HINCKLEY NATIONAL RAIL FREIGHT INTERCHANGE

*Blaby District Council (IP ref.
20040018) Response to
Secretary of State on Application
by Tritax Symmetry (Hinckley) Ltd
for the proposed Hinckley
National Rail Freight Interchange
Project (TR050007)*

Deadline – February 07, 2025

**WORK No.7 A47 LINK ROAD ACOUSTIC FENCE LOCATION GABION WALL OPTION**

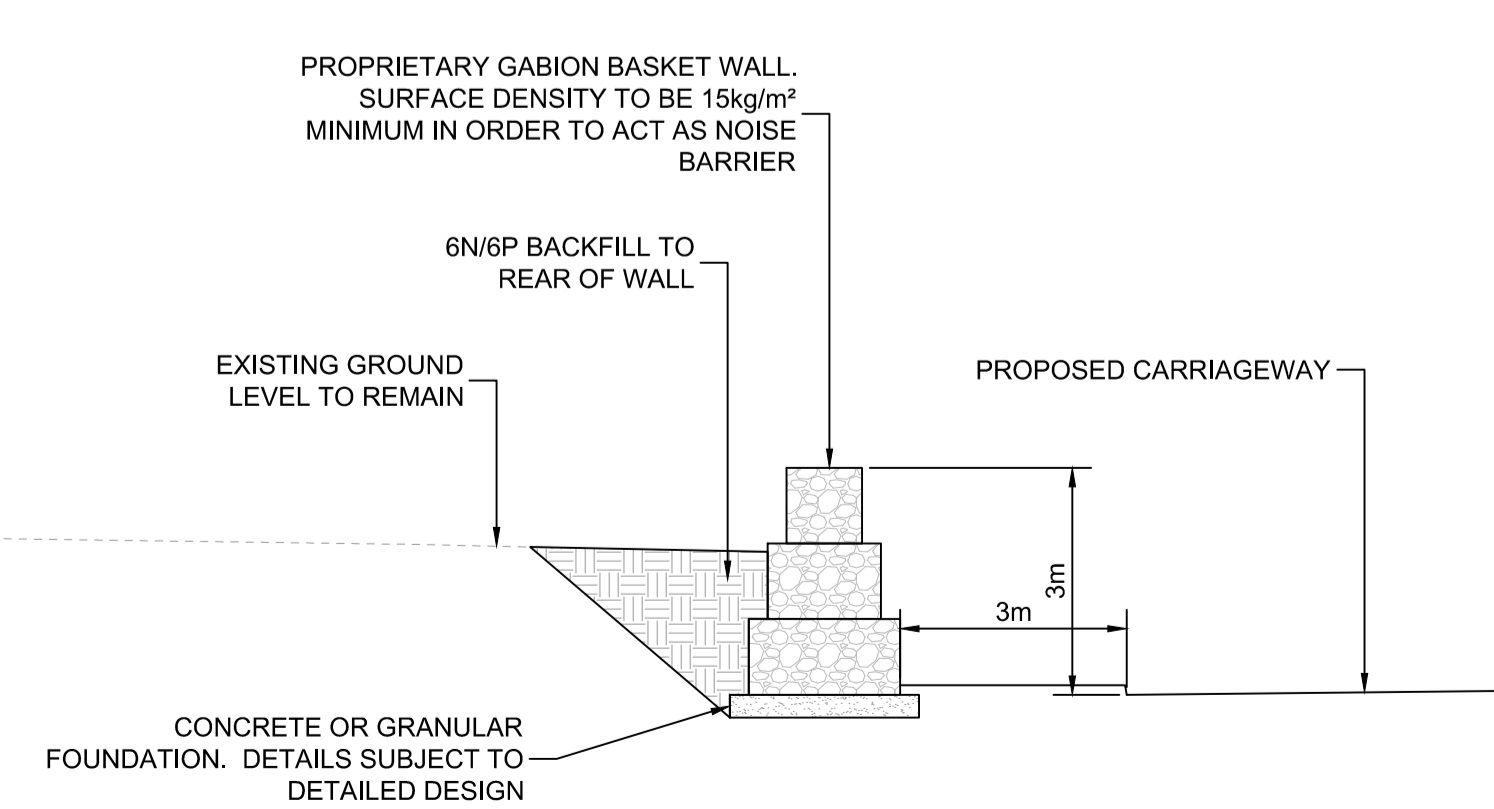
- 4.4. BDC acknowledges the efforts of the Applicant to reduce the impact of the acoustic barriers on the residents of Aston Firs and agrees that the gabion wall proposal is aesthetically preferable to a fence. BDC also acknowledges that moving the acoustic barrier on the south eastern boundary away from the boundary with the Aston Firs site and closer to the highway, thus placing it closer to the source of the noise, is beneficial. Although it is noted that there is a relatively minor increase in noise levels at Aston Firs this is predominantly caused by the break in the screening to accommodate the bridleway. BDC is content that the Applicant has tested a variety of barrier scenarios and that the gabion option is the most preferable.

- 4.5. BDC recommends that the treatment of the new 12m buffer between the acoustic barrier and the Aston Firs site is carefully considered to ensure that natural surveillance is maintained in order to ensure it does not attract antisocial behaviour.
